Response to Submissions

Prepared for: **Grand Noble Project 1 Pty Ltd**

The State Significant Development Application (SSD-96272465) for residential development with in-fill affordable housing at 11–23 Rangers Avenue, Mosman was publicly exhibited between 4 December 2025 and 17 December 2025. During the exhibition period, a total of 185 submissions were received.

01. Shadow Proposed 9am June 21

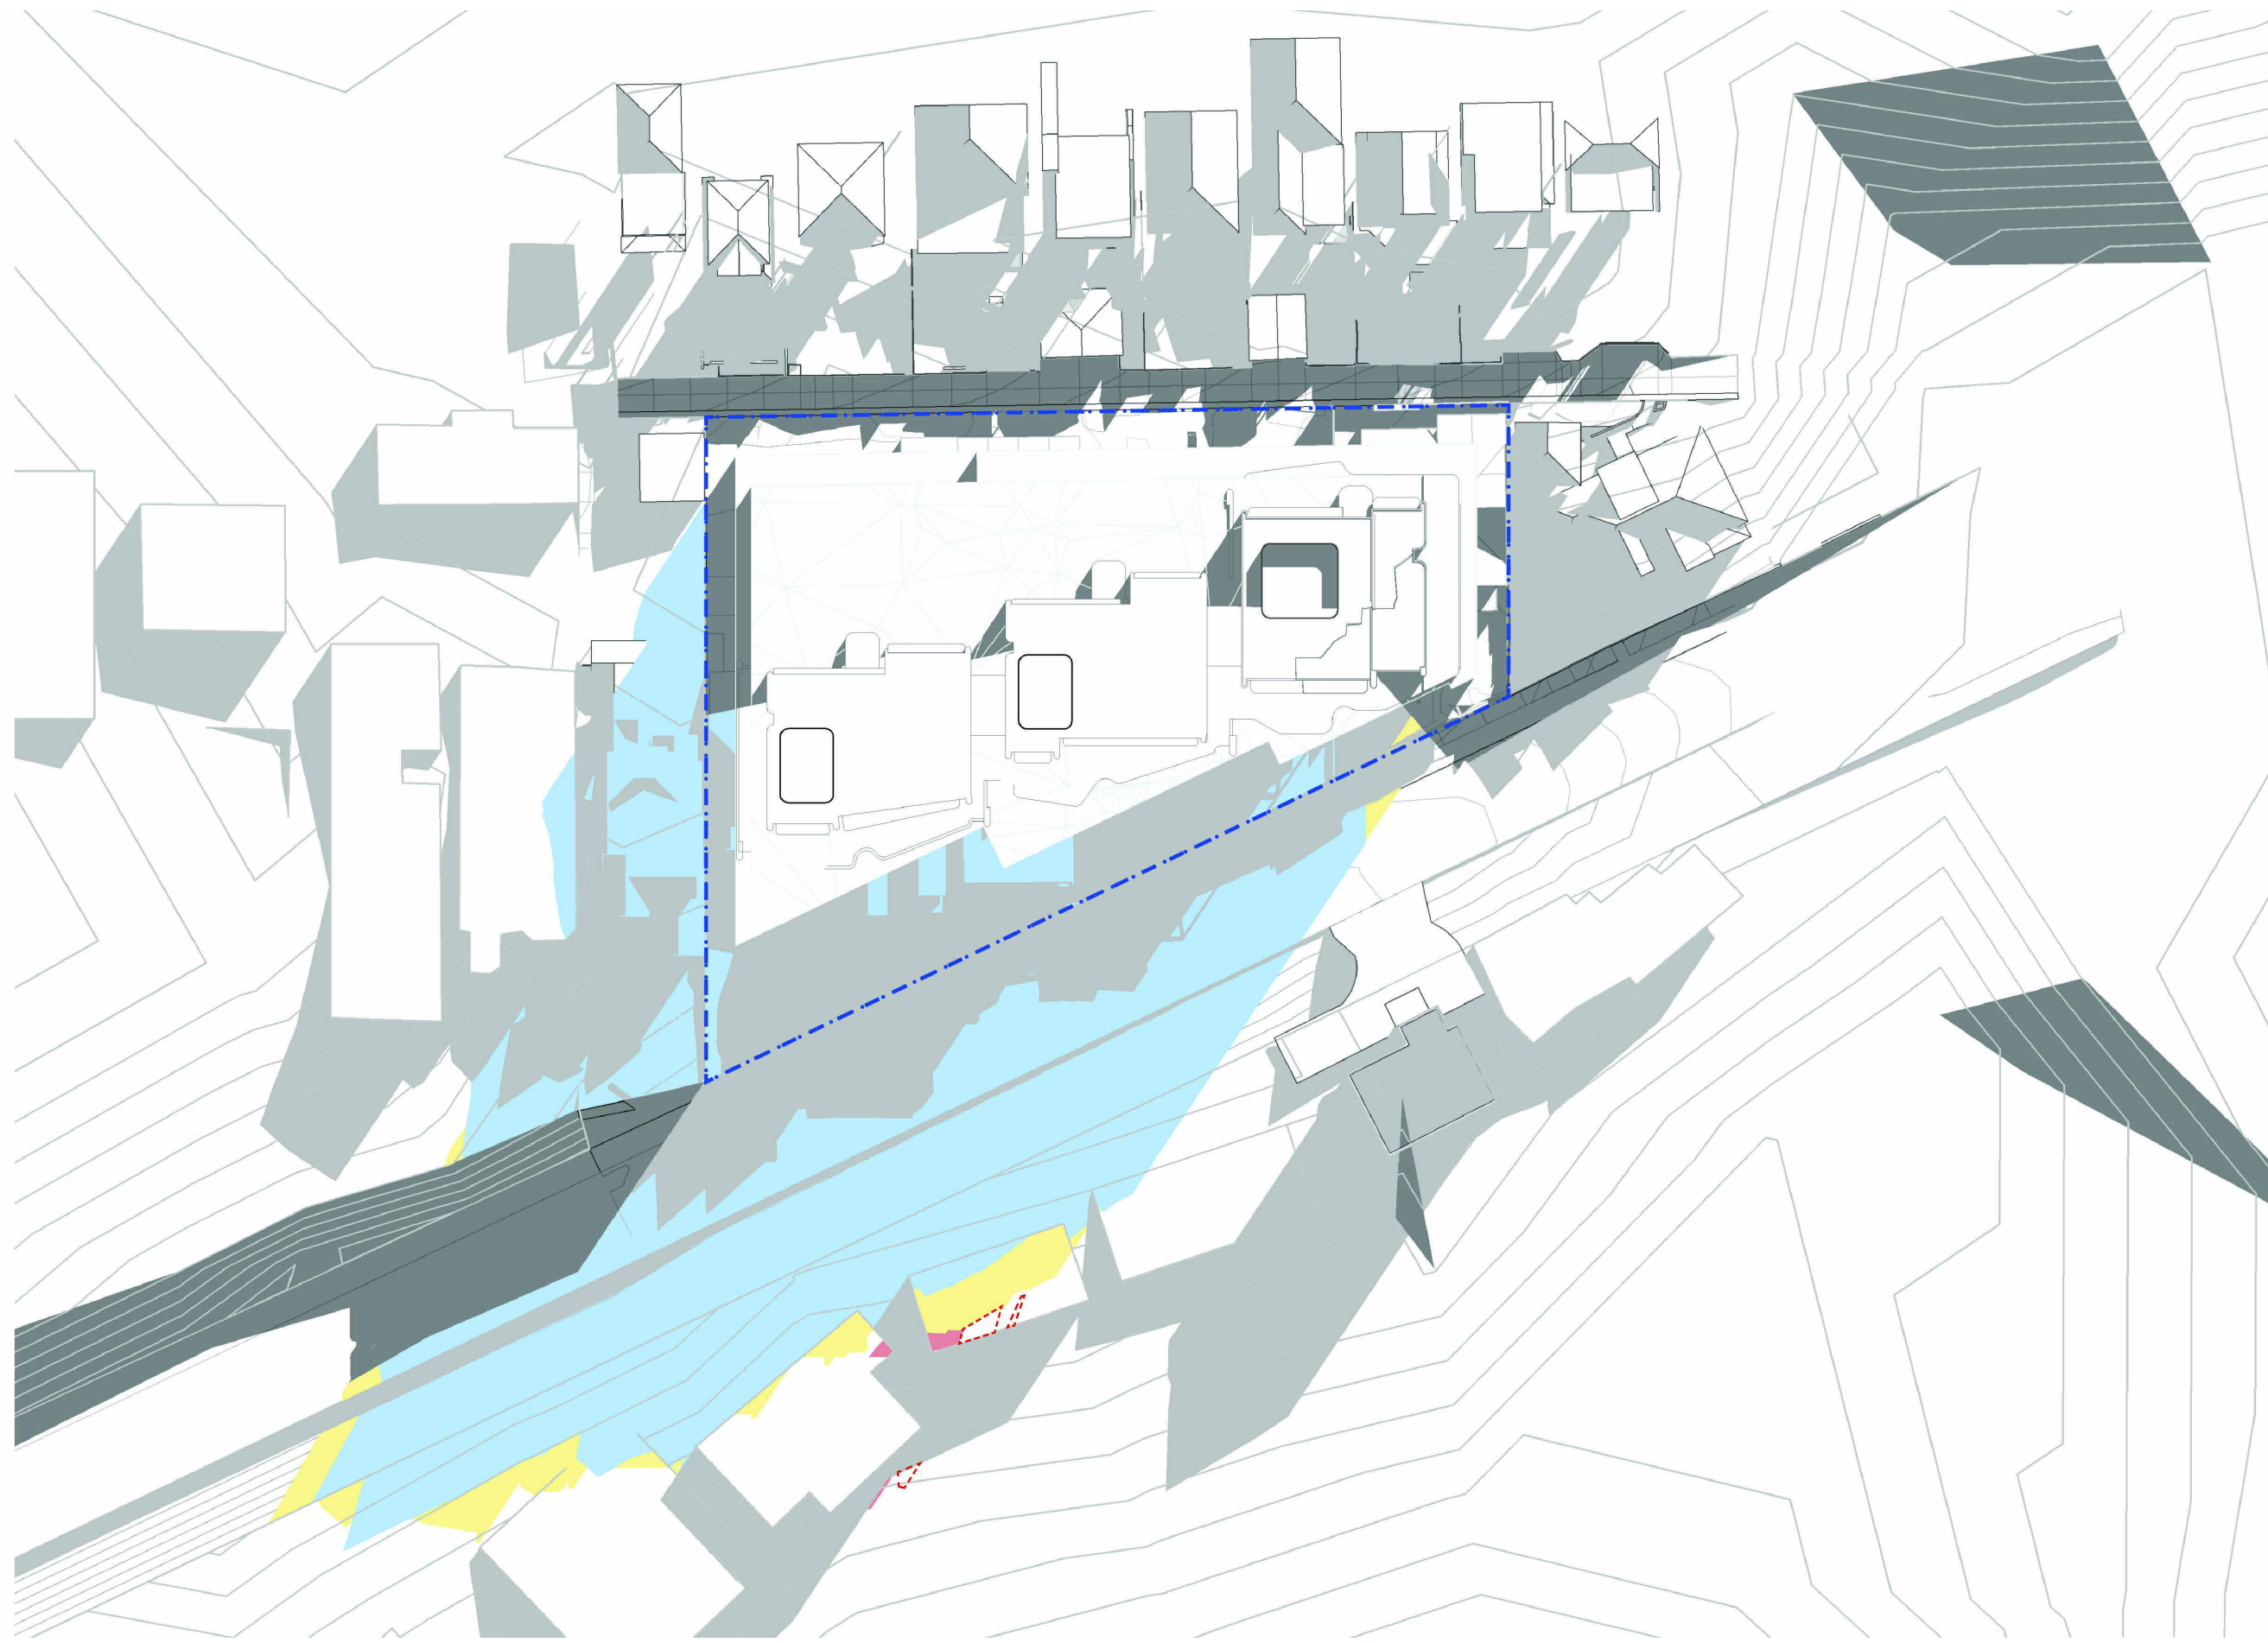
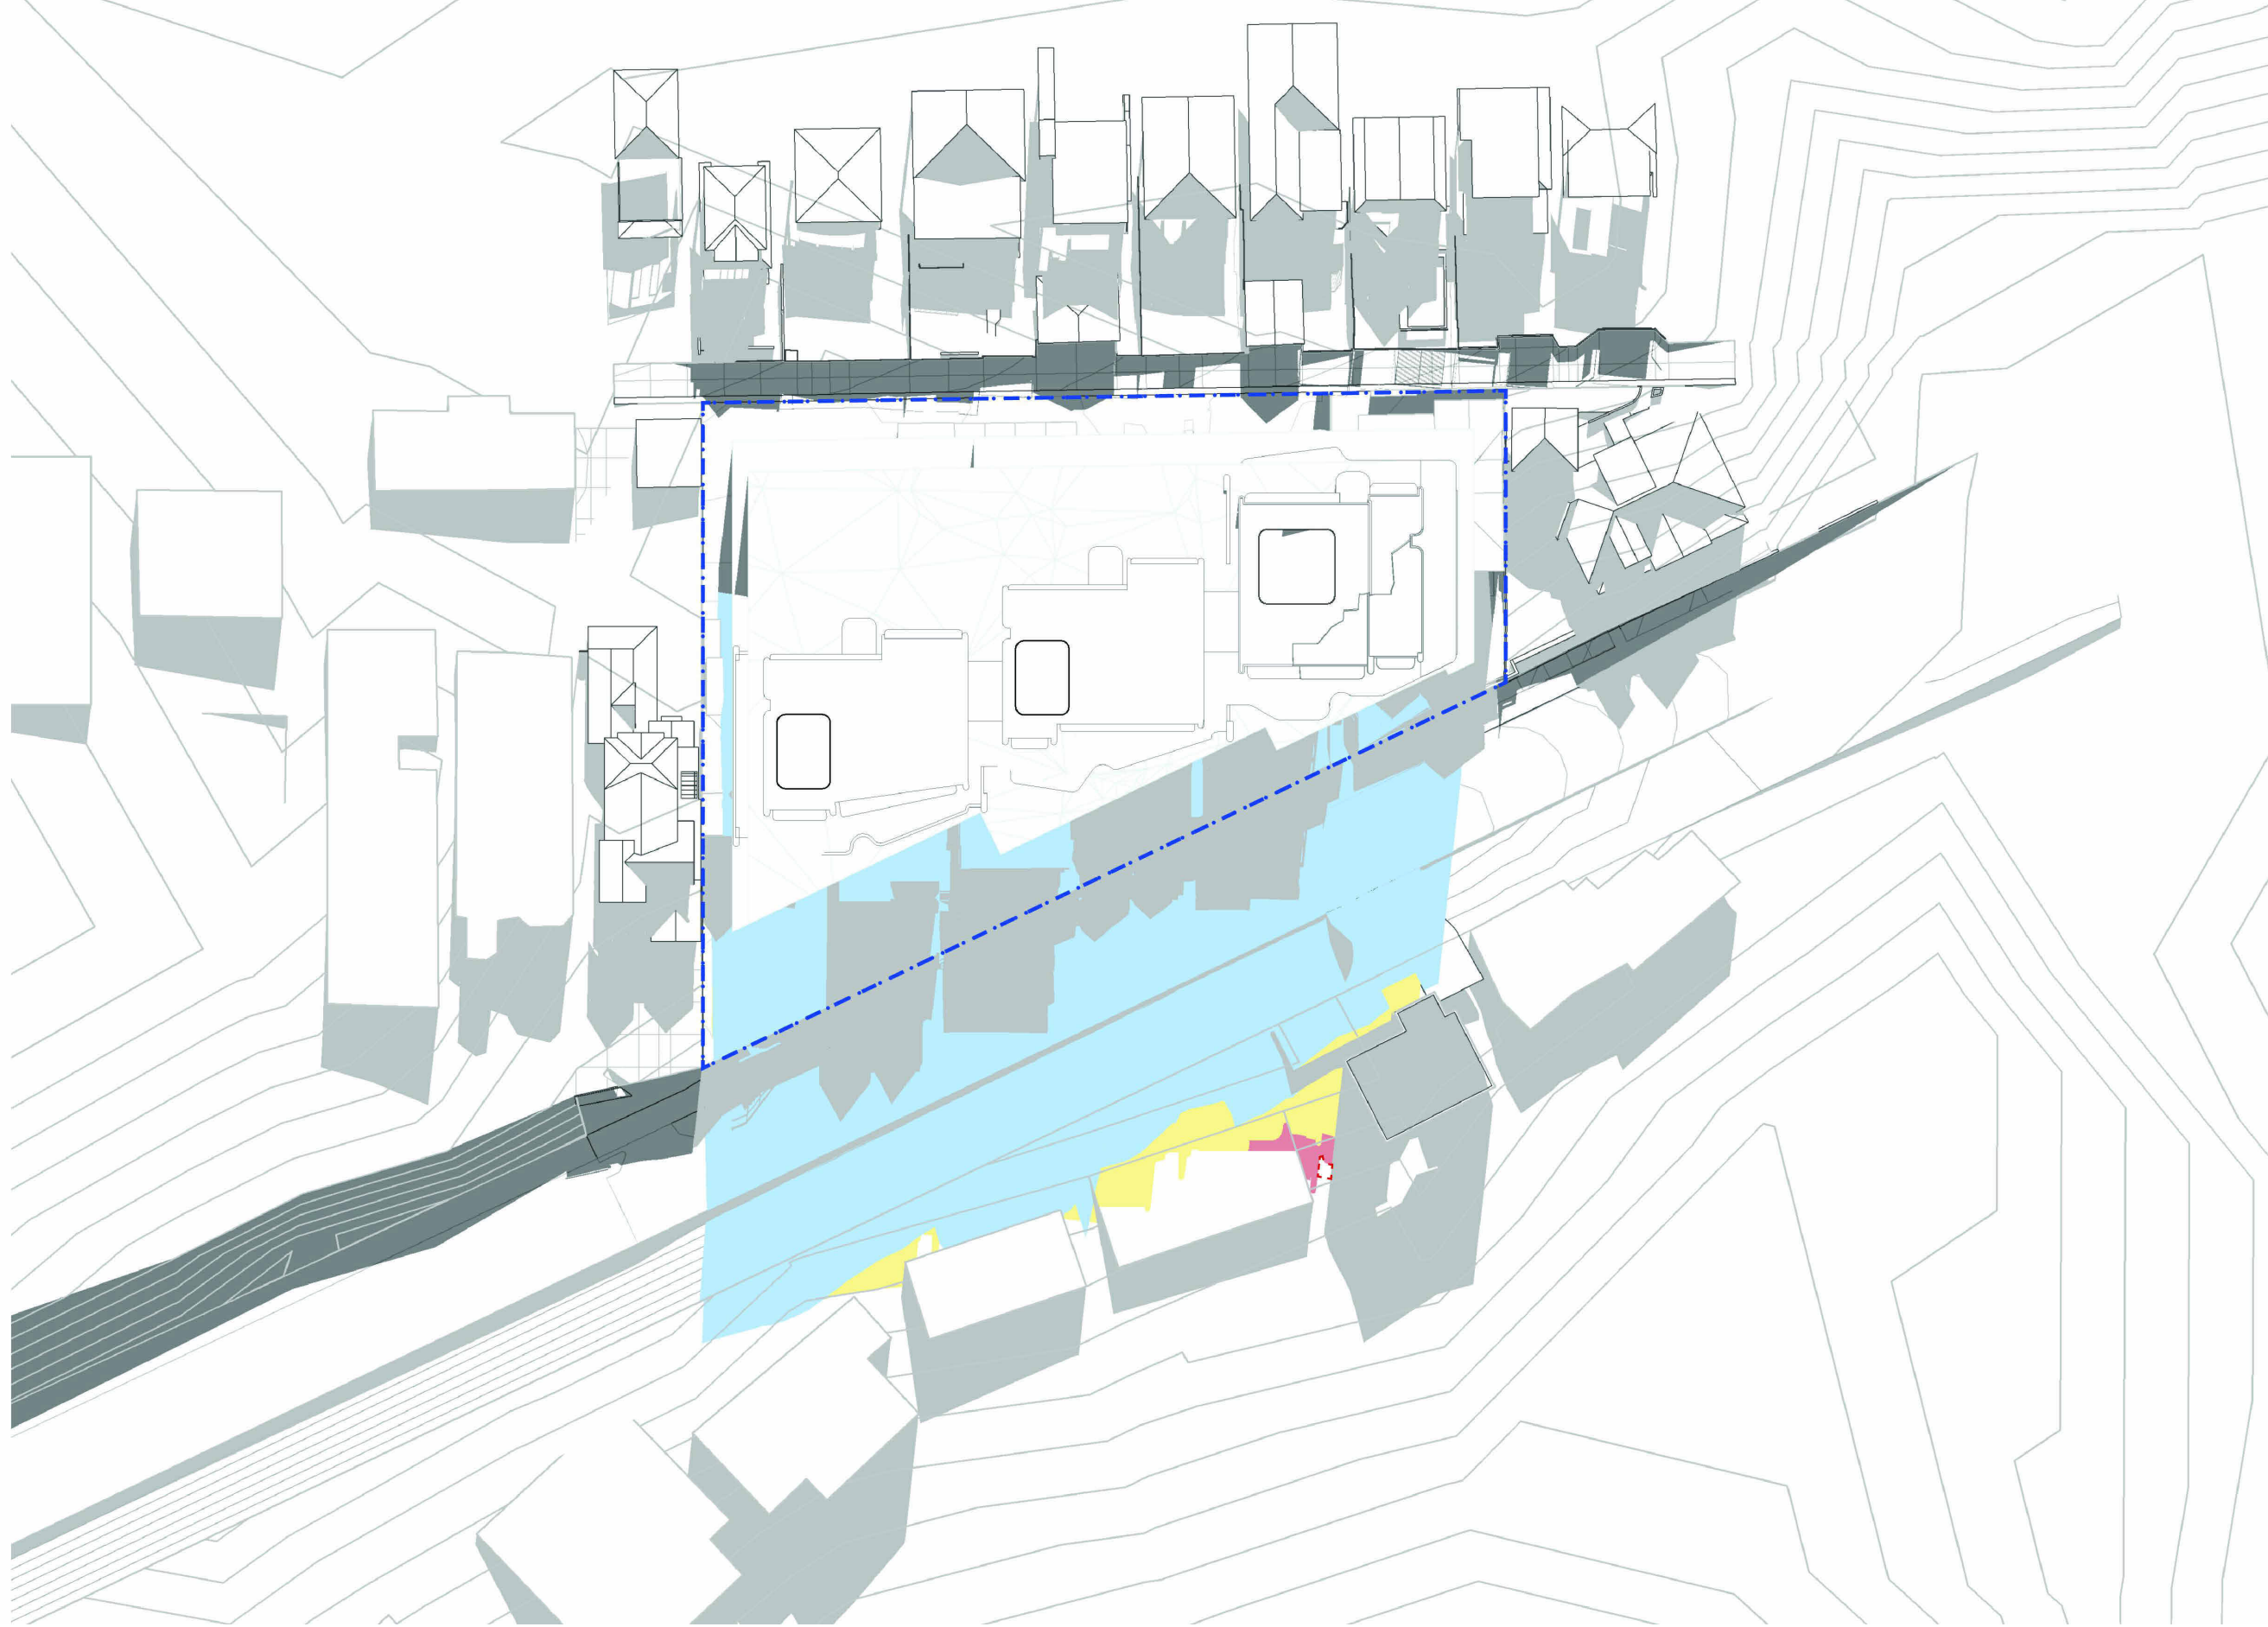
- Raises concerns regarding view sharing and amenity impacts, stating the proposal prioritises views from within the development, fails to demonstrate minimisation of view loss to surrounding properties, provides inadequate separation and transitions, and may worsen already constrained solar access south of Rangers Avenue.
